Re: Magnum Builders
6623 Rimrock NE, SAD 227 Lot 7, Block 1 Volcano Cliffs
Request Permanent C.O. – Not Accepted
Engineer's Stamp dated: 9-18-17 (D10D010)
Certification dated: 3-6-18

Based on the Certification received 3/8/2018, the site cannot be accepted for release of Certificate of Occupancy by Hydrology until the following comments are addressed.

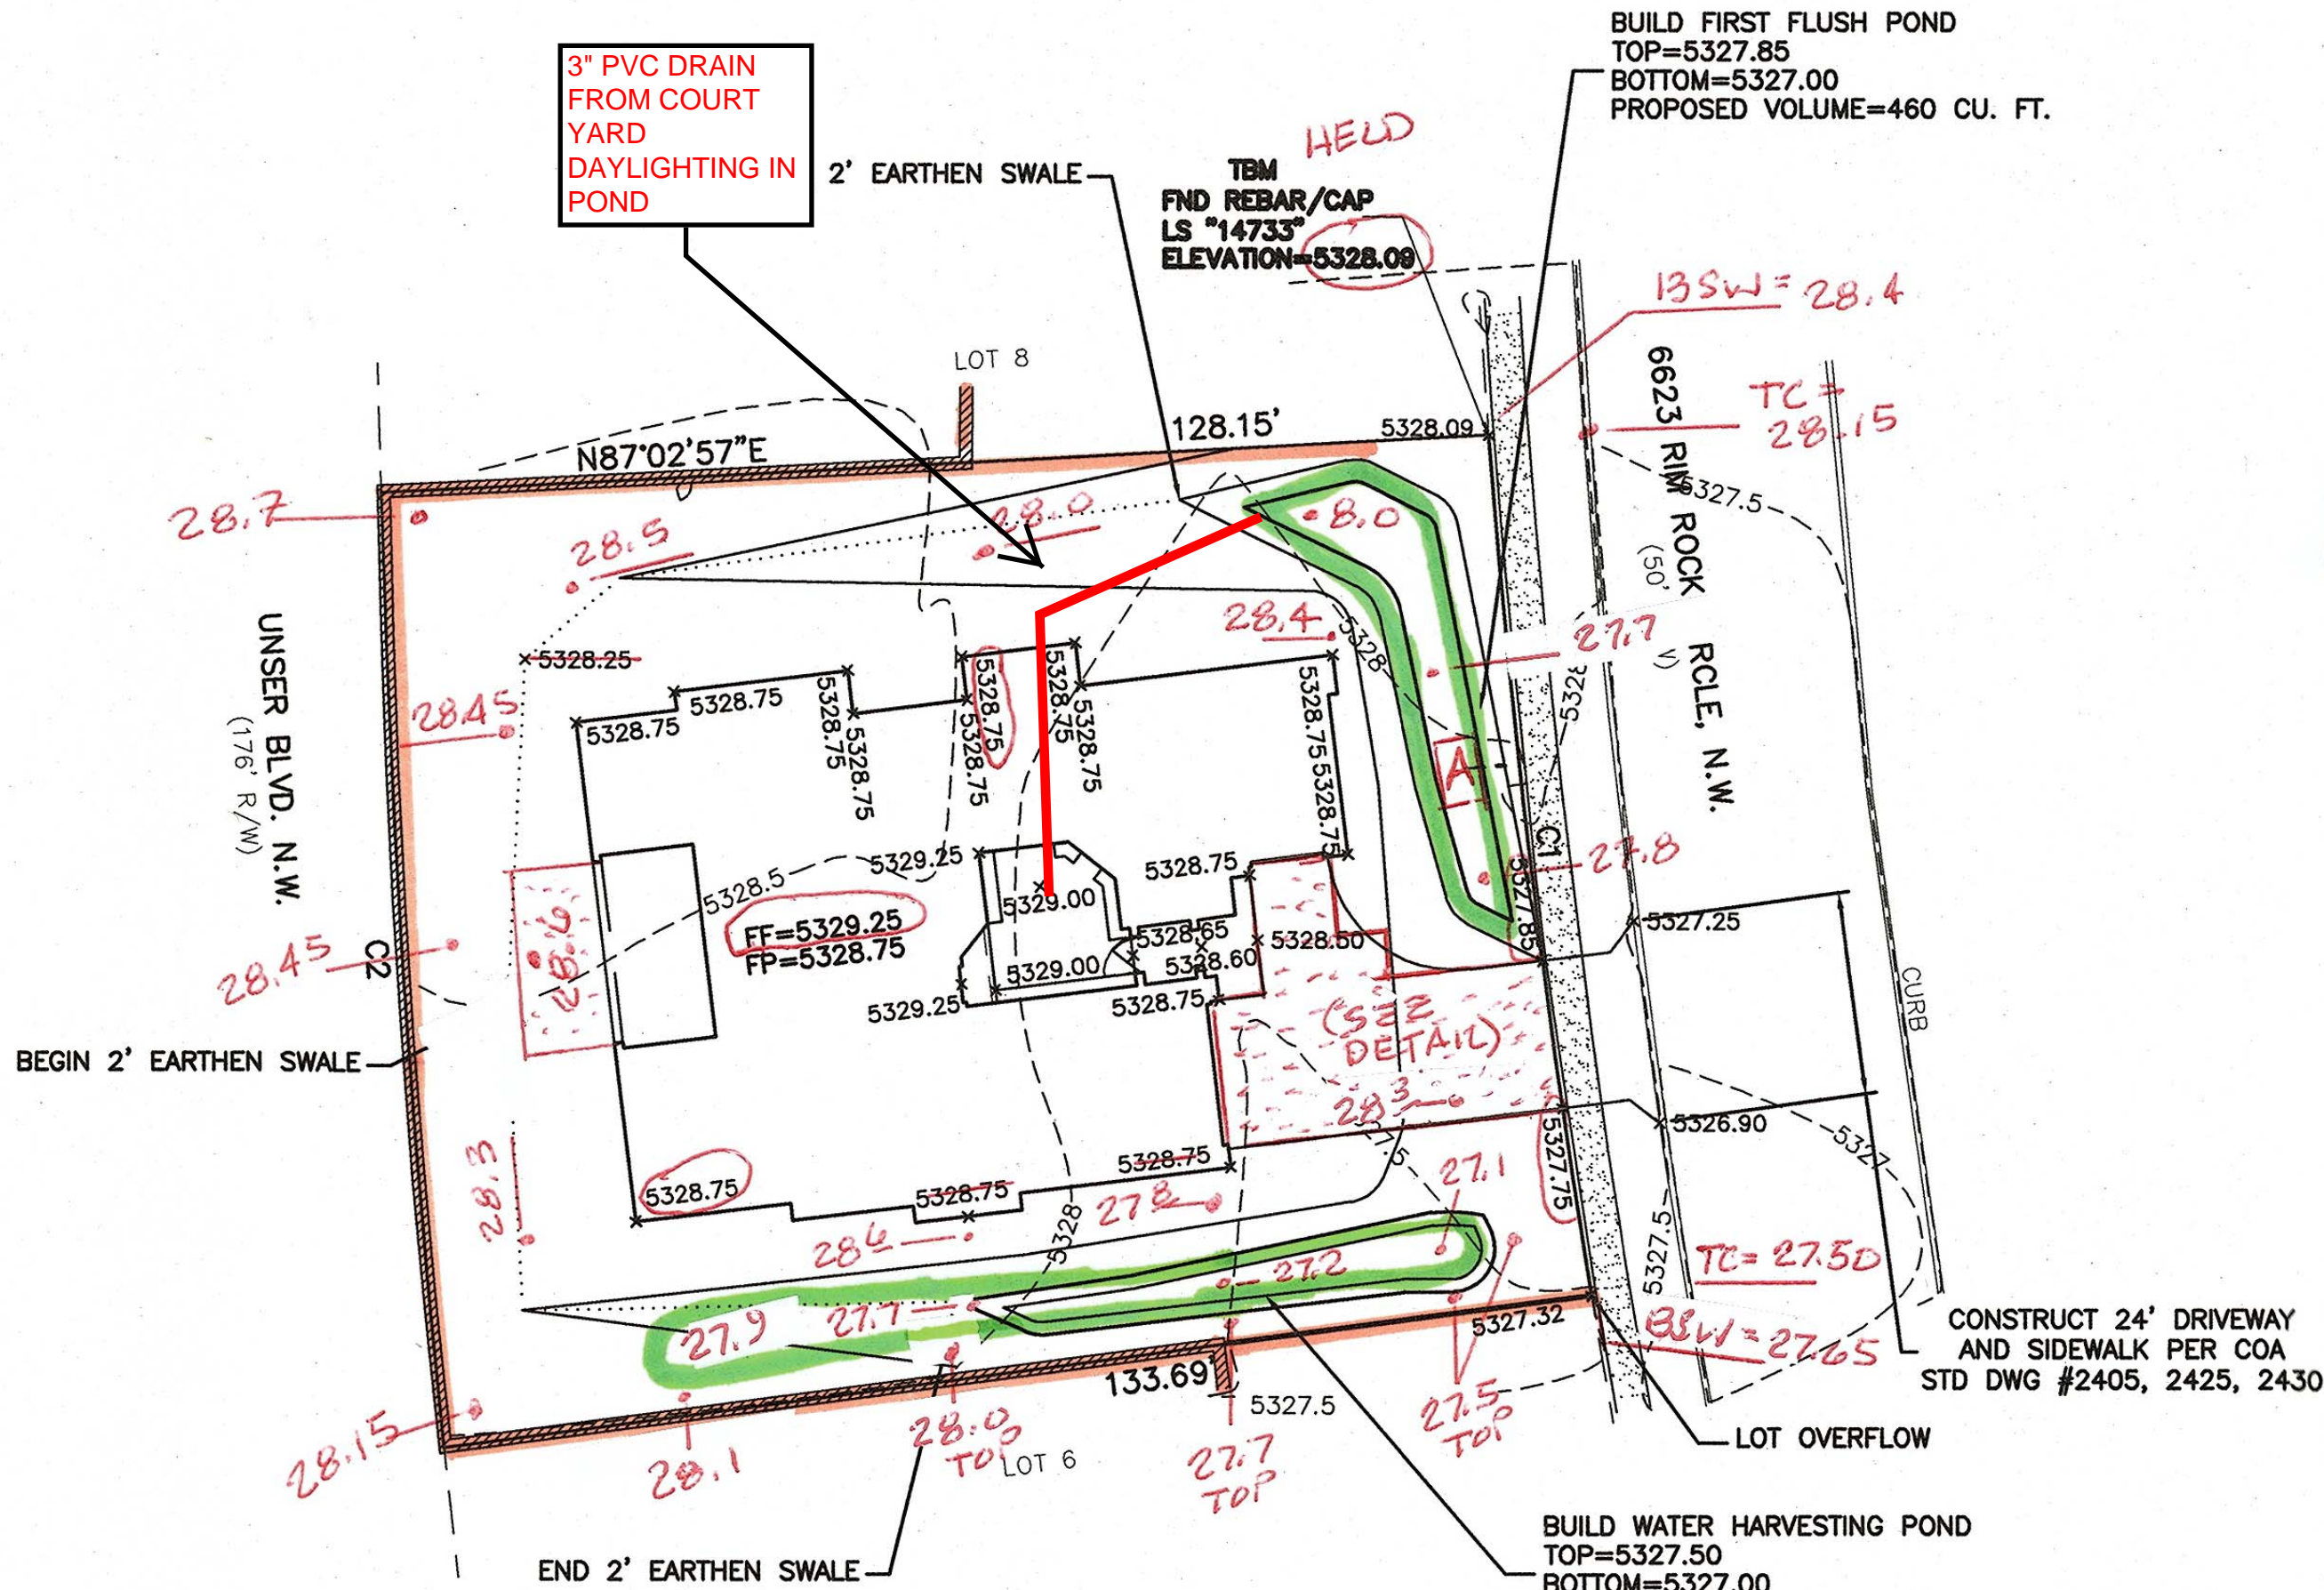
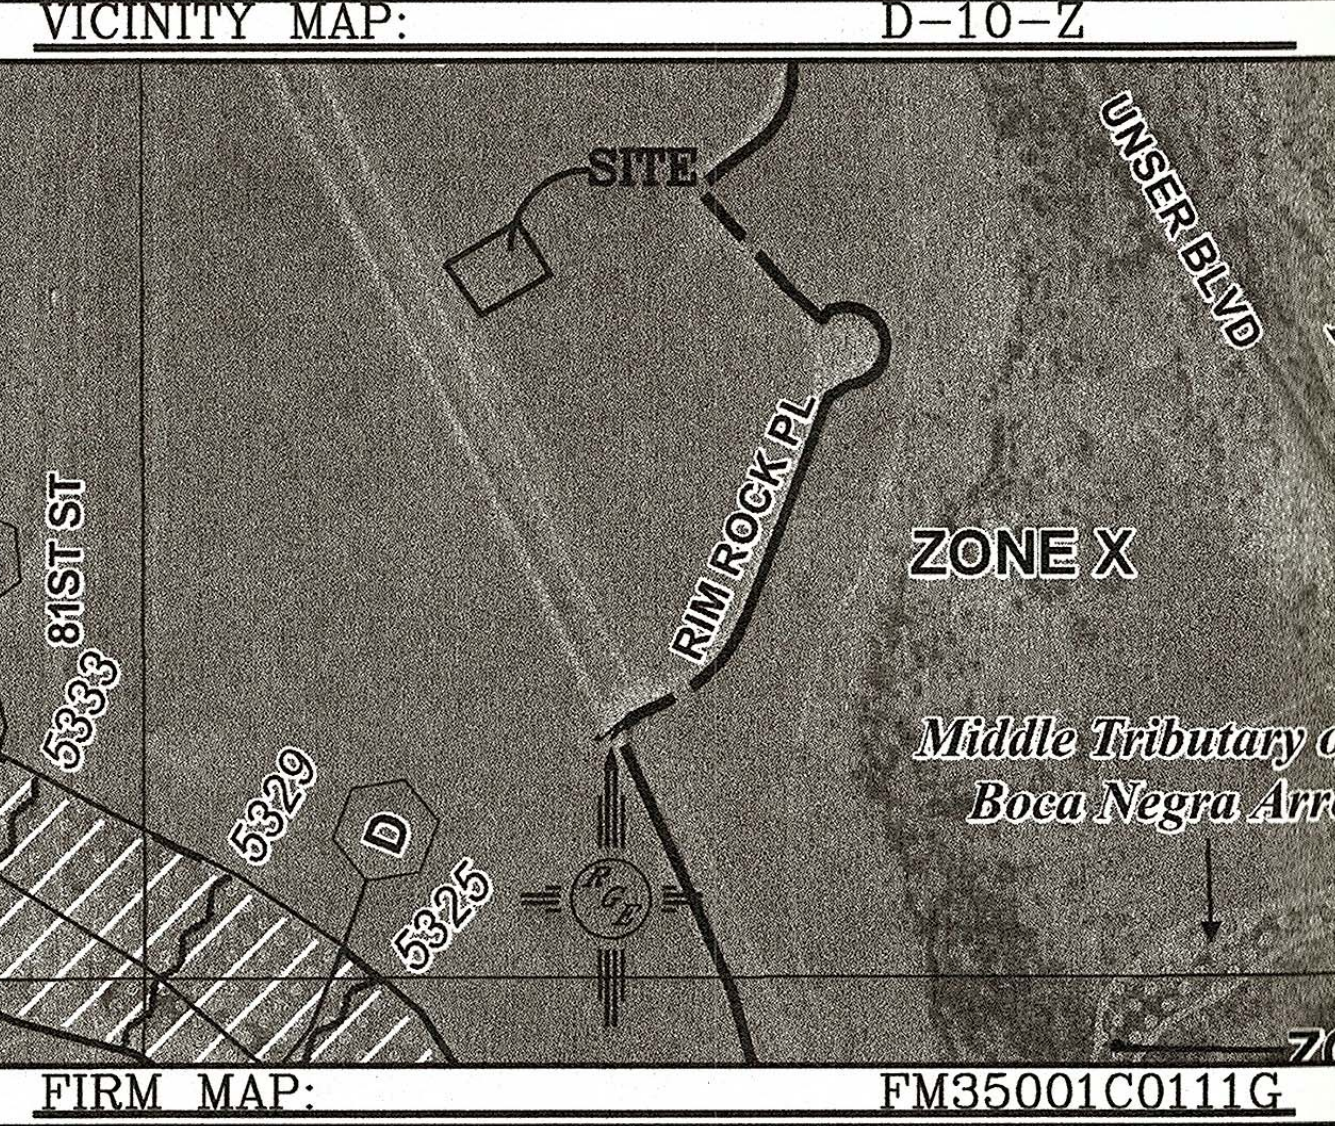
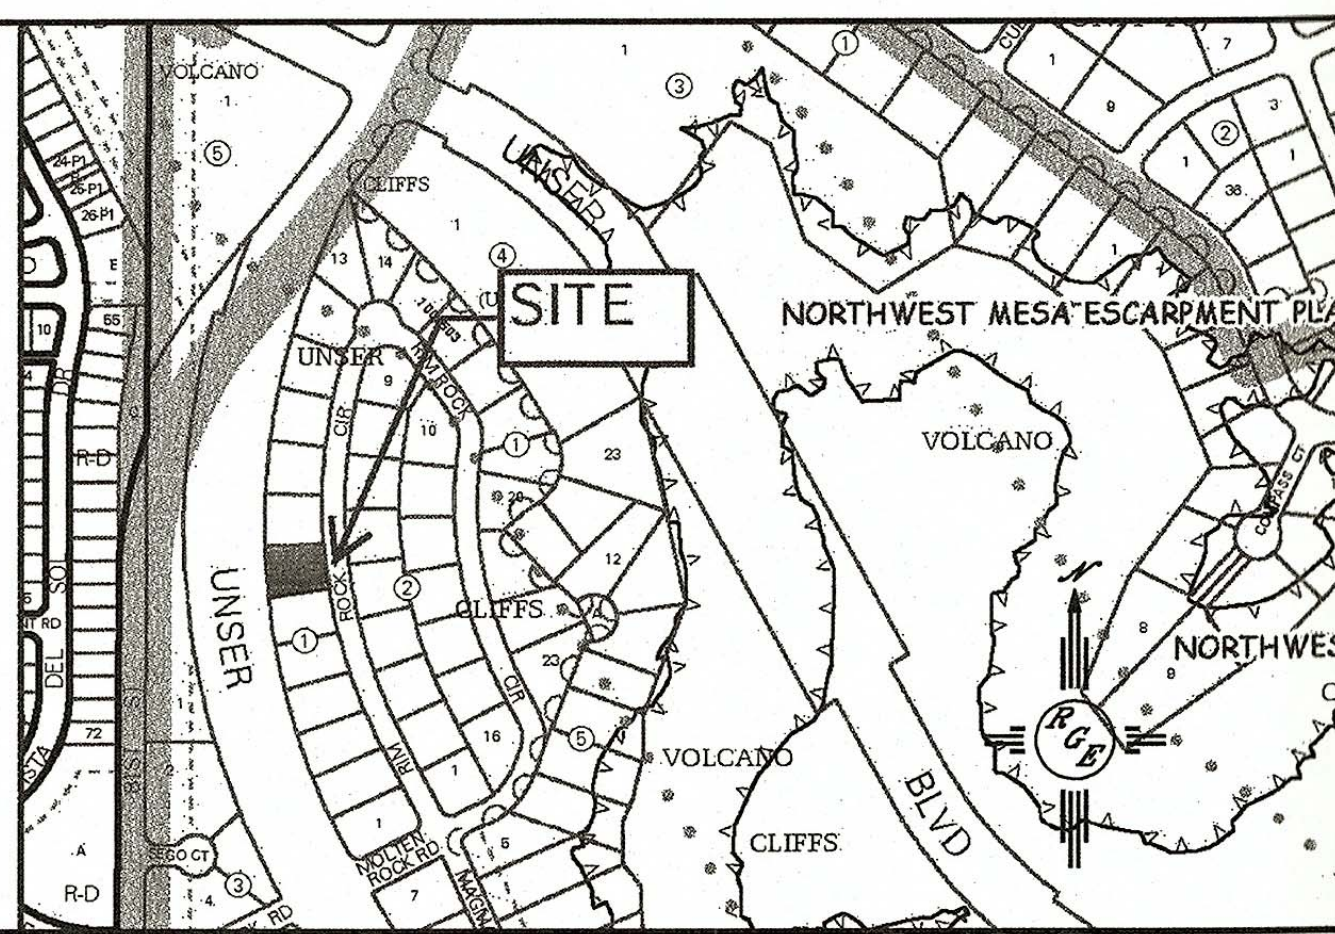
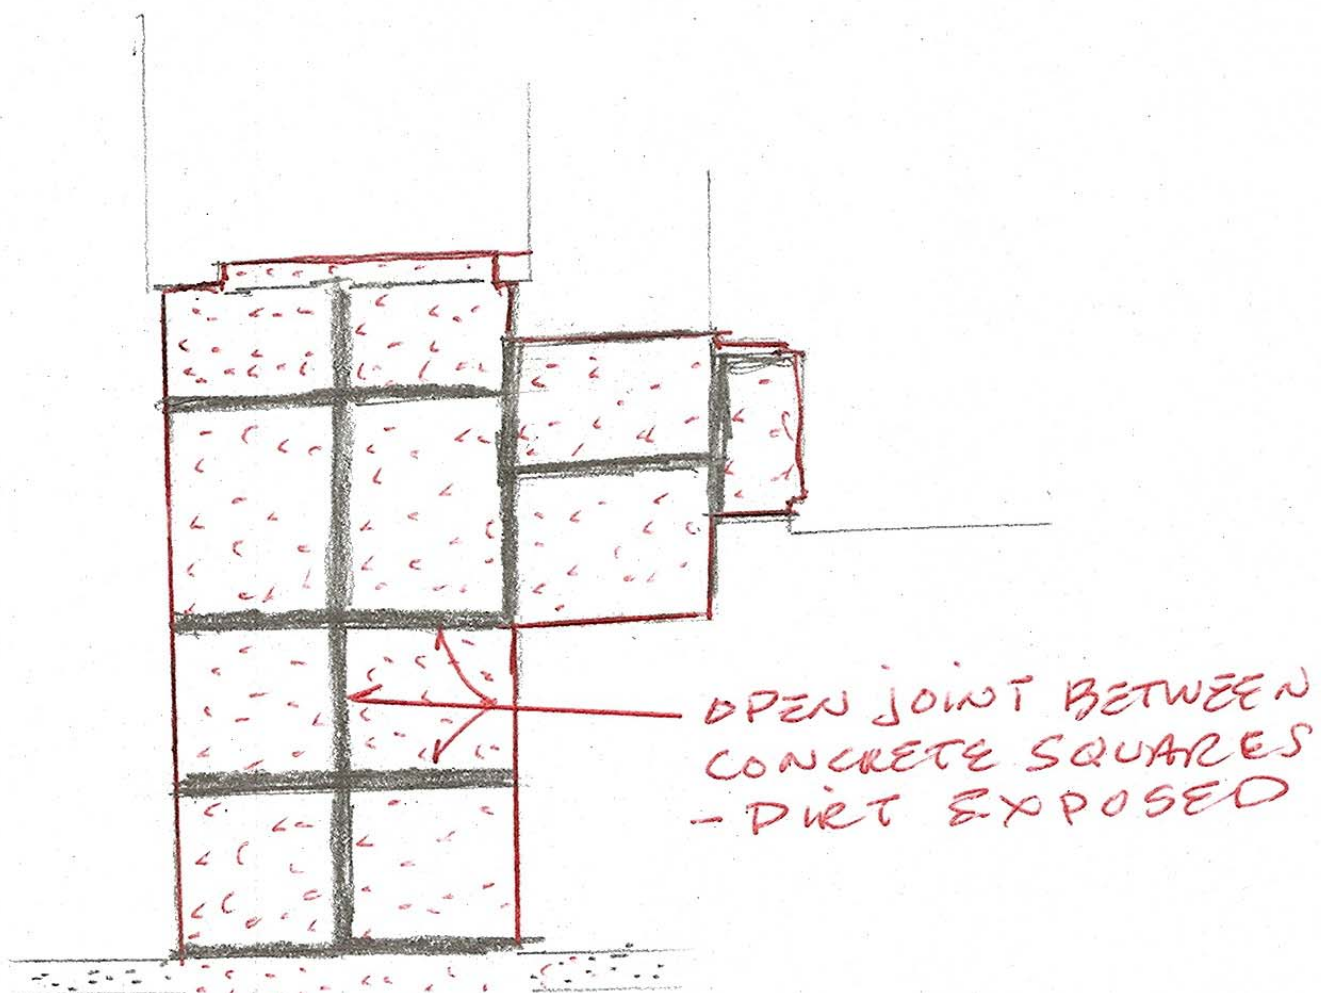
- Remove the dirt piles and debris in and around the site.
- What is the purpose of the 3" pipe coming from under the home?
- Provide how flows escape the atrium/open area near the front door.
